October 5, 2023

The following comments are the Environmental Public Health comments on the Fowler Creek Guest Ranch, CU-23-00003. A well site inspection needs to be done for the existing well that was drilled in 1994 to approve it as a public water system source. With the expected numbers of people that will have access to the water system, this system will be classified as a Group A, transient, non-community water system. The final approval for the system will be done through the Washington State Department of Health.

EXHIBIT 16 - SITE PLAN - FOWLER CREEK GUEST RANCH

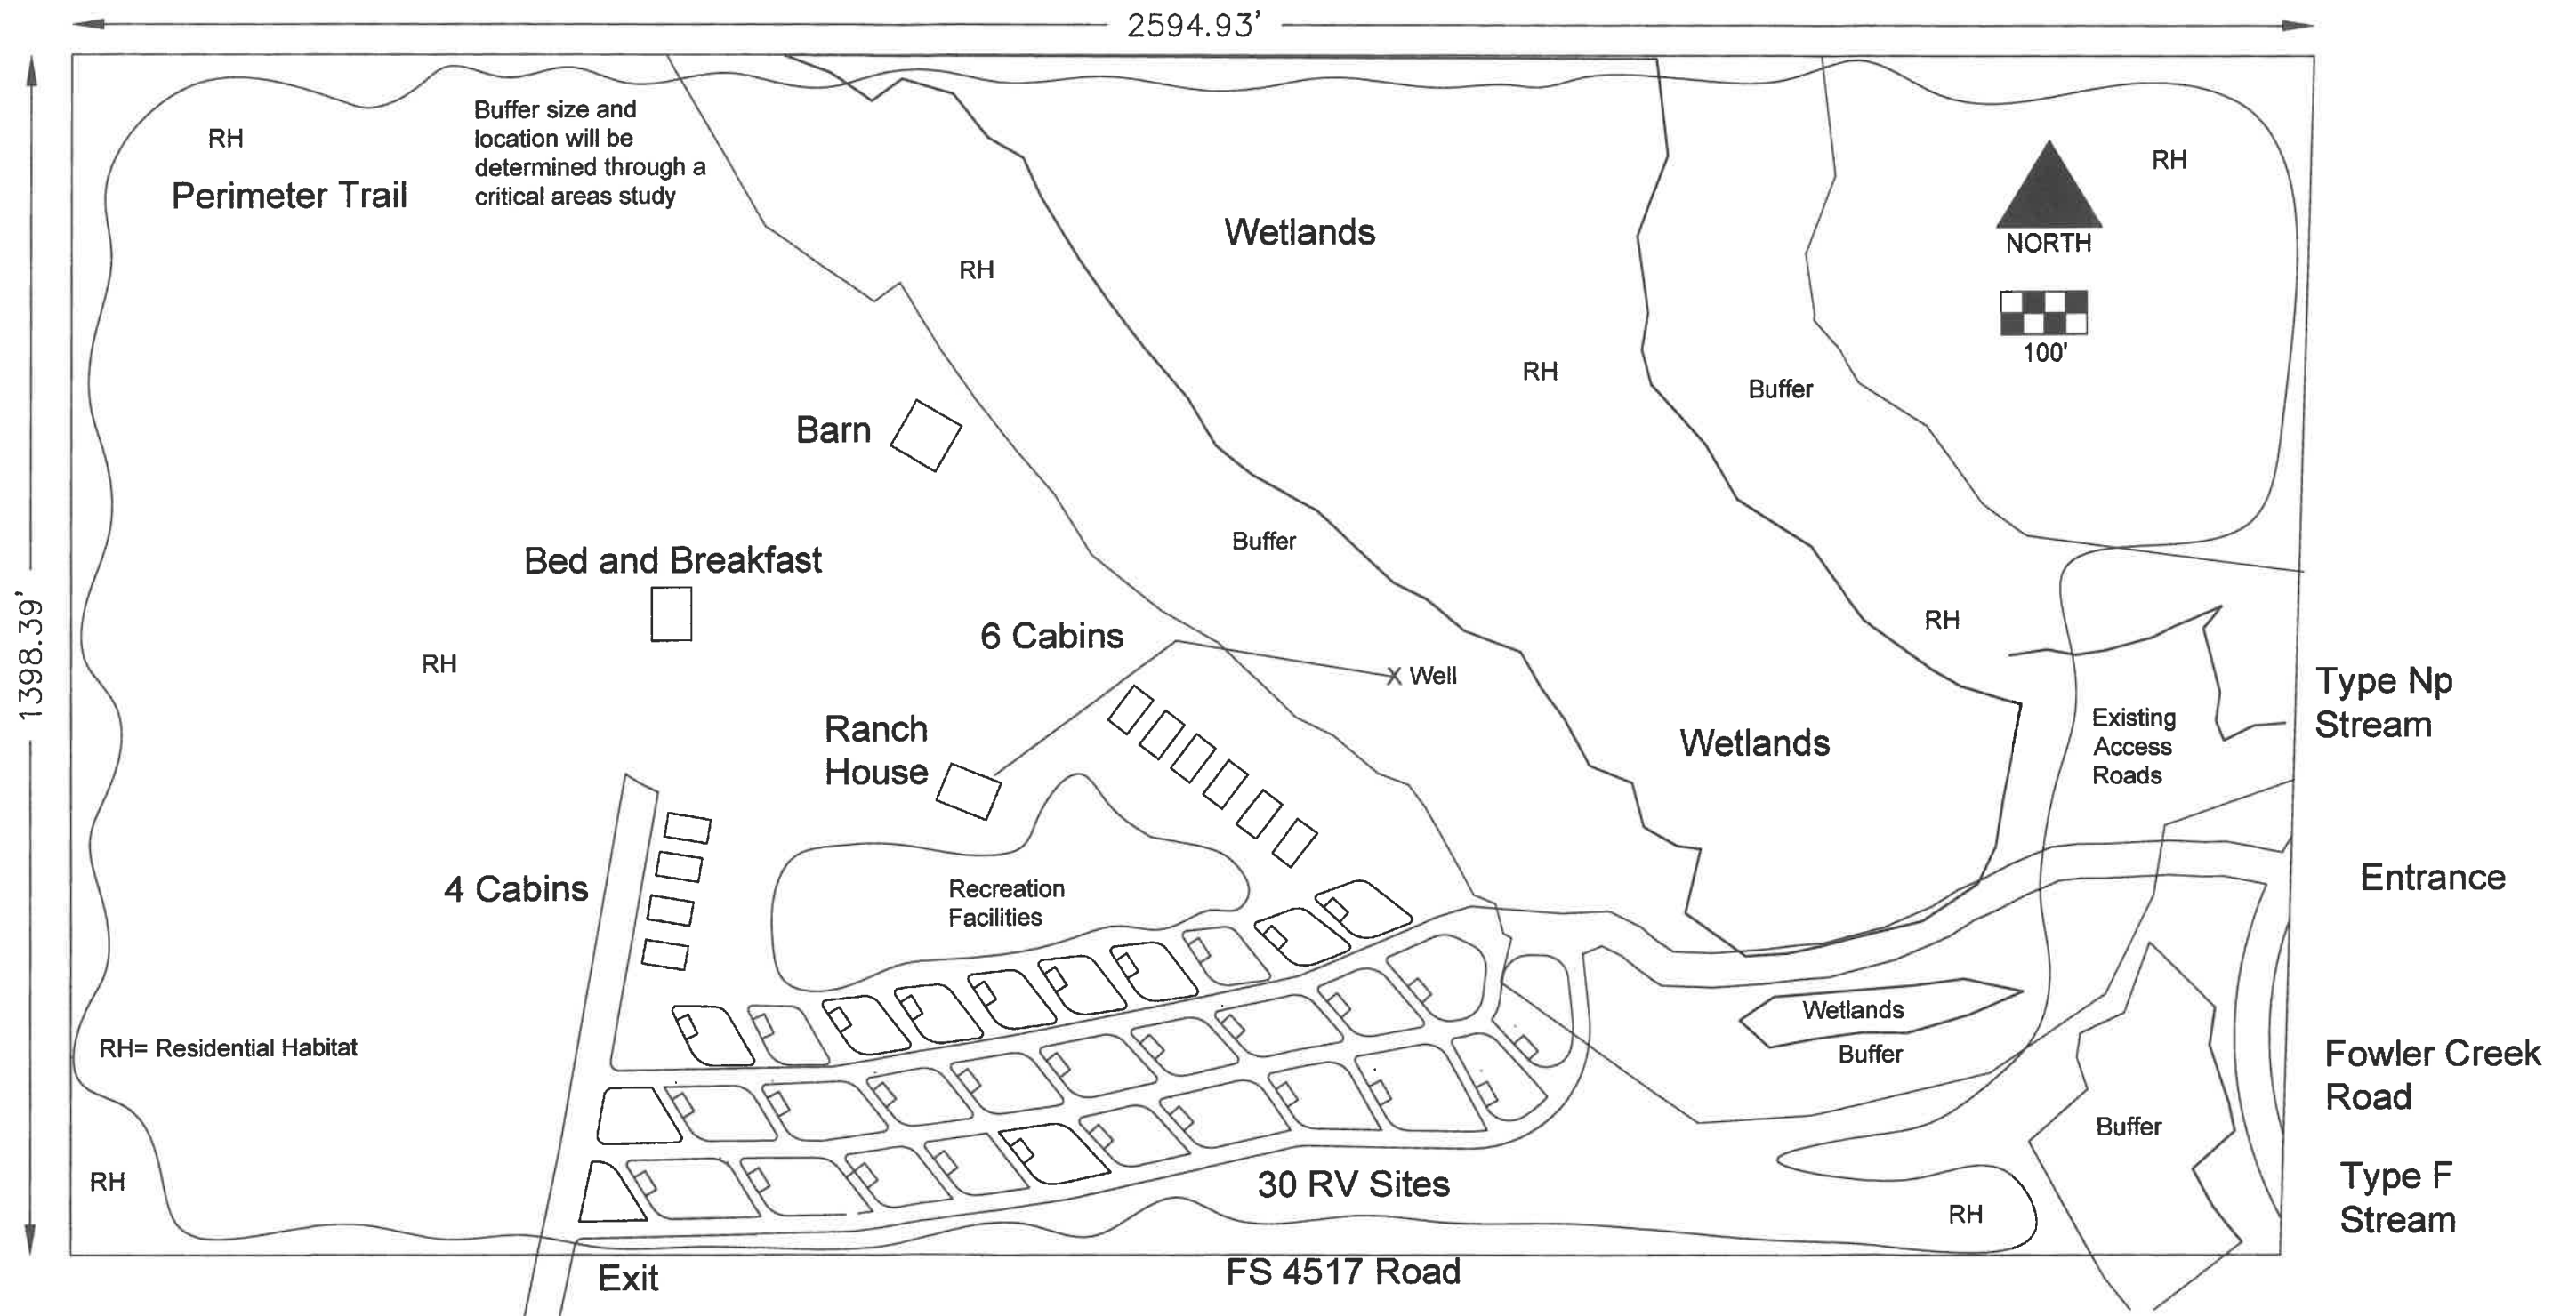
The applicant is proposing to use one lot for the placement of multiple drainfields that will produce 6000 gallons per day. According to Kittitas County Code chapter 13, when a drainfield will be utilized to treat more than 3500 gallons per day, it is considered a LOSS (large on site sewage system). Therefore, prior to construction of the system, the construction plans must be submitted to the Washington State Department of Health (DOH) for approval of engineering and to ensure the system will not create a health hazard. There are some questions about the flow numbers that were calculated for the project and where those numbers were derived. The EPA manual is an excellent reference and is one that DOH regards as a good resource for calculating potential flows.

Additionally, a site evaluation will be required to be done to determine the size and placement of the proposed drainfields.
